The application supercedes a previous application from 2022 (2022/92356) and introduces a new layout which is detrimental to both existing properties on the cul-de-sac end of Moat Hill Farm Drive and Clough House with the following impacts:

1 PROPOSED SITE LAYOUT  
1 : 500

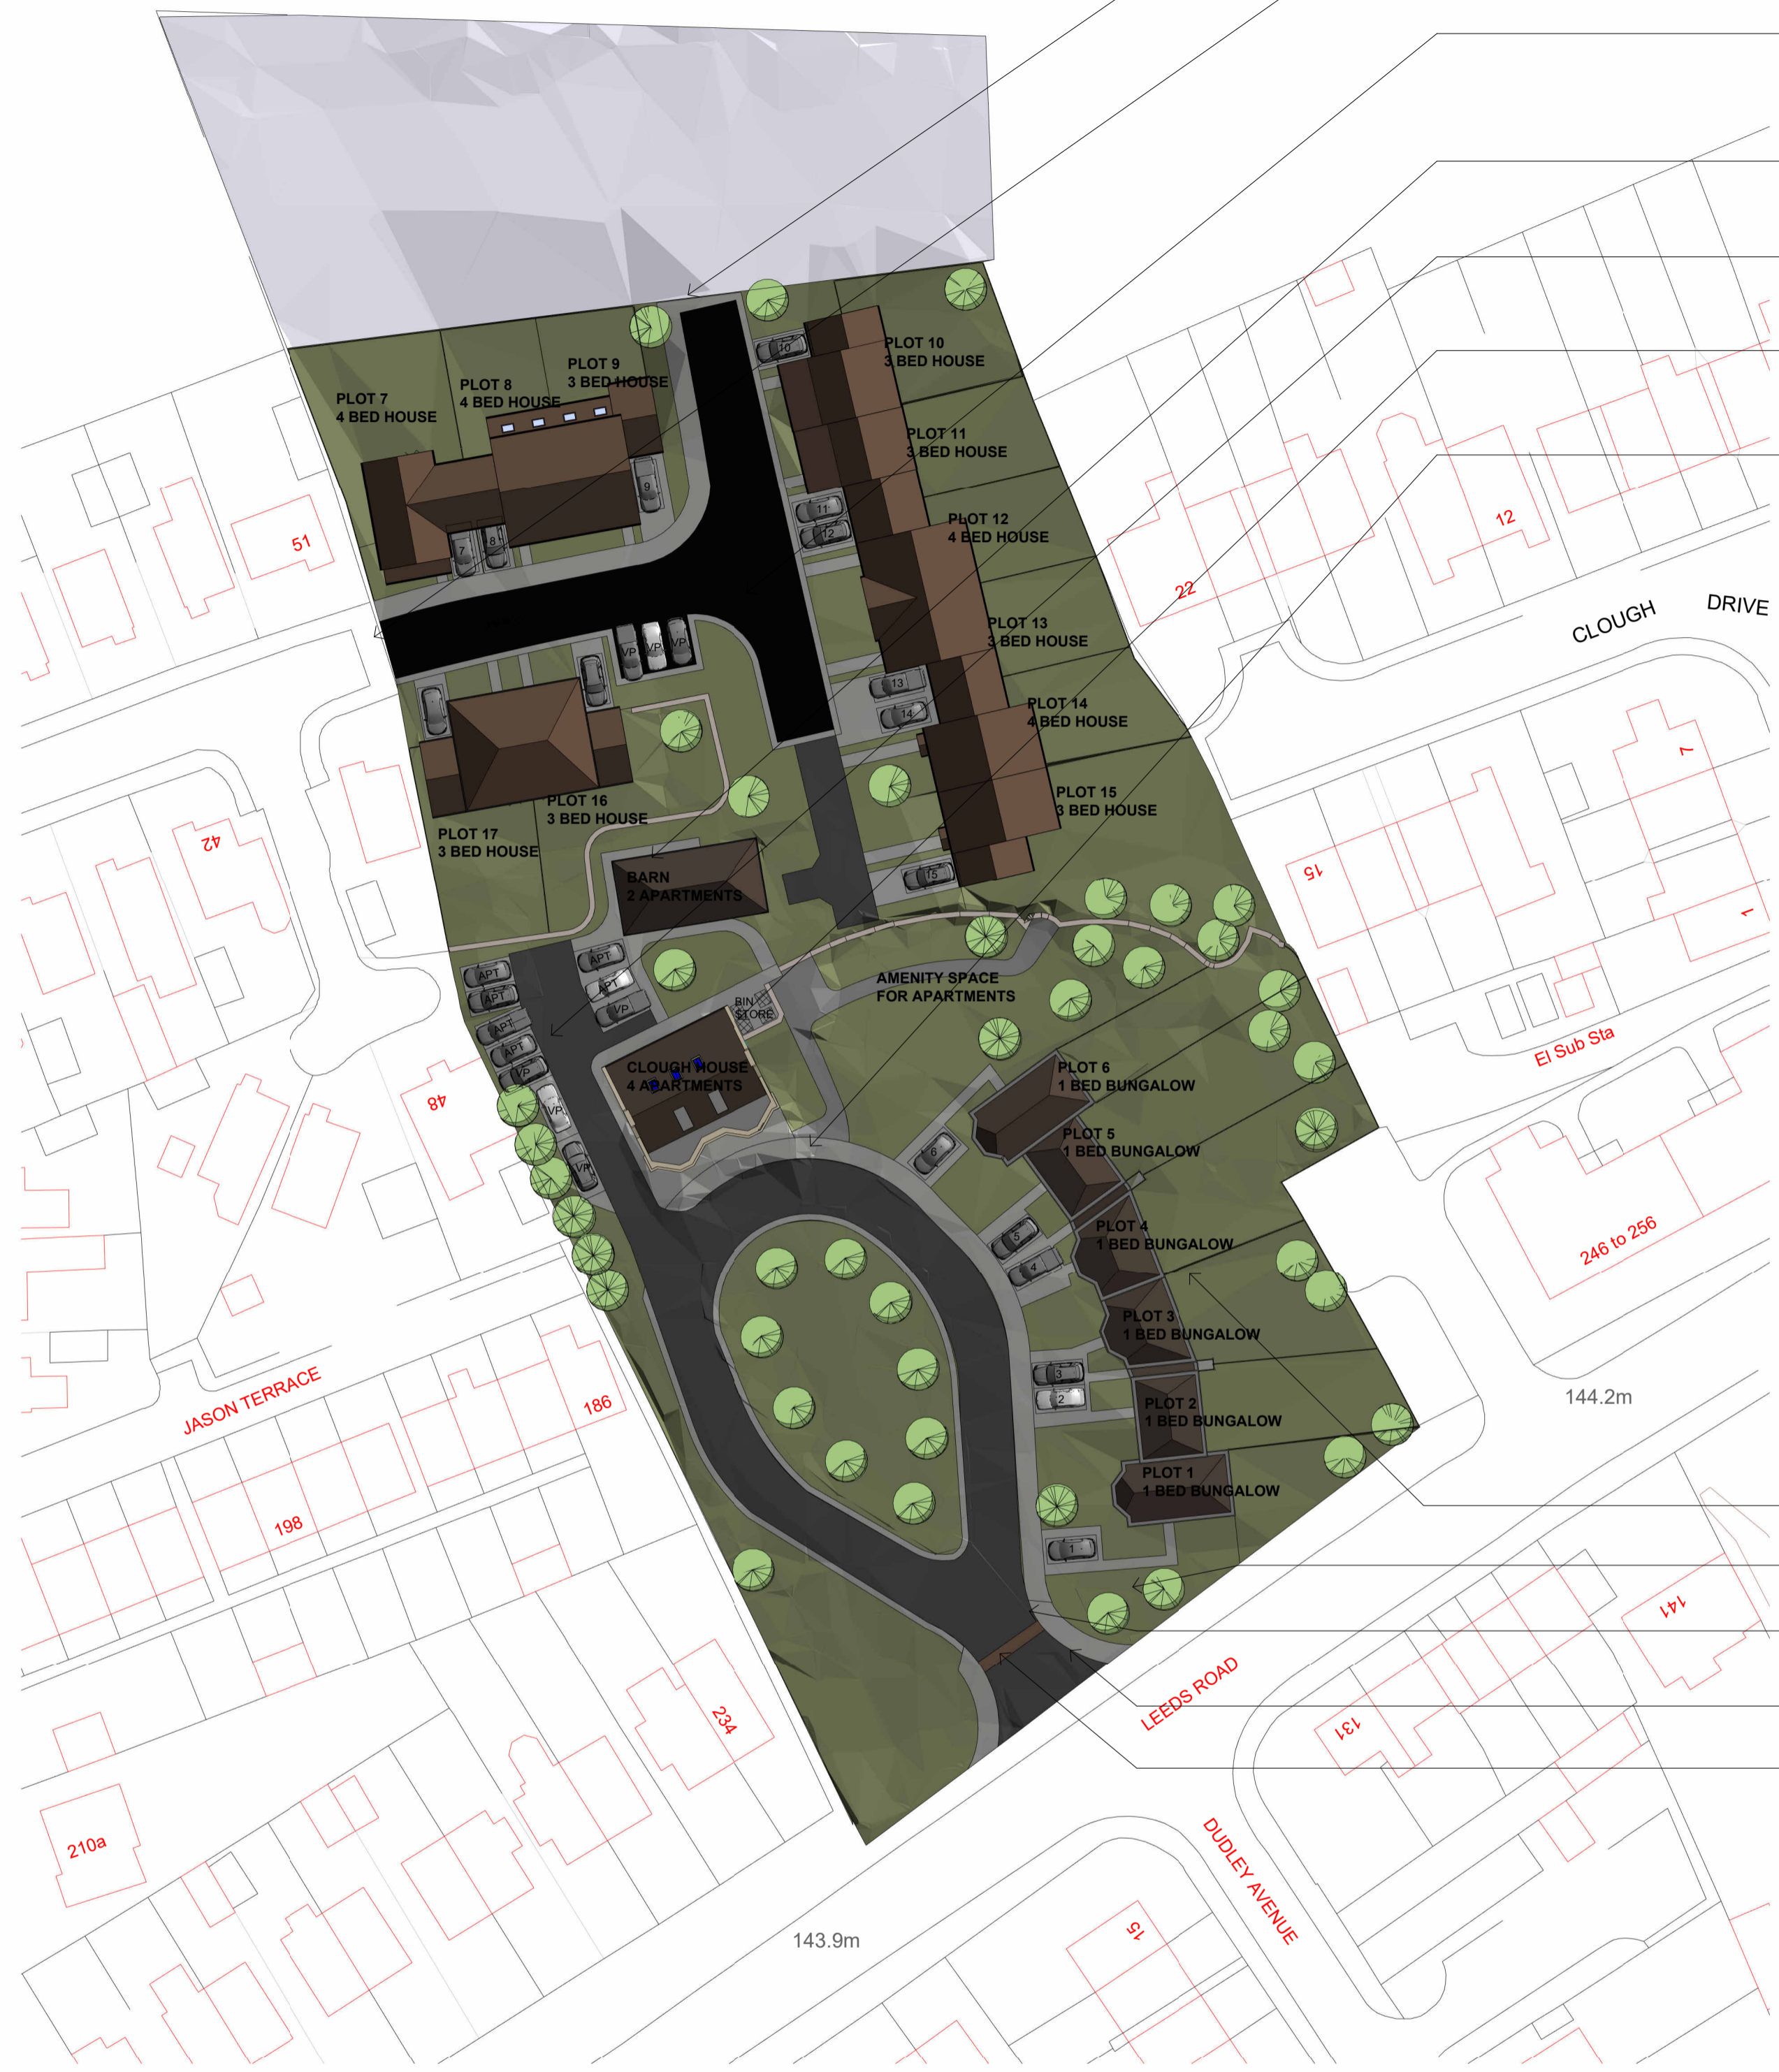
1. Plots 16 & 17 on the current application replaces the previous landscaped space with trees behind Clough House and the barn which presents an inferior proposal compared to the last one. Significantly this will detract from the historical prominence of Clough House on the line of sight from the Leeds Road boundary as the new houses would be viewable and deminish the character of the site which was much loved by the community. If the original concept of a tree planted landscape was retained, it would screen plots 7, 8 & 9 and therefore the character of Clough House and the barn would be preserved.

2. Clearly plots 16 & 17 are a tight squeeze and to accommodate these dwellings, the pavement widths in front of these have been reduced to 0.6 metres (less than 2 feet) compared to the existing 2 metre wide pavements along the adjacent Moat Hill Farm Drive road. This is detrimental to the safety of pedestrians and potentially road users. The existing Moat Hill Farm Drive road being proposed as the access road to the north of the site, is a single carriageway of 5.5 metre width. Grocery delivery vans are in everyday use and when parked on the road, they are usually blocking the road unless they are park half way on the pavement which would force pedestrians onto the road if this occurred on such a narrow 2 foot / 0.6 metre wide pavement. As in many communities, children play together outside of their homes therefore the proposed 2 foot wide pavements is likely to put them in danger and hinder their enjoyment whilst growing up.

3. Expectations from the National Planning Policy Framework as amended in 2023 include that safe and suitable access to the site should be achievable for all users. The 0.6 metre width pavement is less than the standard width of a wheelchair or child double stroller and therefore access is not inclusive for all users of the site.

4. The application has a number of inaccuracies. For clarification the site only has one existing access road which is the gated drive to Clough House from Leeds Road. To the east and west of Clough House are existing housing estates which are cul-de-sacs with road turning points. Moat Hill Farm Drive has inherent topographical challenges exasperated by the increasing number of housing developments being served by this road (namely Jason Terrace, Rose Terrace, Leeds Road properties with rear vehicle access onto Moat Hill Farm Drive) in addition to the two existing housing developments. Inclement weather and the crossroads junction onto Leeds Road represent additional traffic pressure. There have been a number of minor accidents and near misses on Moat Hill Farm Drive which do not appear to have been noted on the Transport Assessment. There is a significant height drop down to the potential access point to the Clough House site and currently there is no clarity how this level difference would be made up and the impact on the existing houses, residents and community. In contrast, Clough Drive to the west of Clough House serves far fewer houses, experiences less traffic congestion, is a shorter route to Leeds Road, doesn't have a similar significant level difference at the turning point adjacent to Clough House and the access to Leeds Road is not hampered by a crossroads. The road is also wider and therefore would present a safer access point to the proposed development plans.
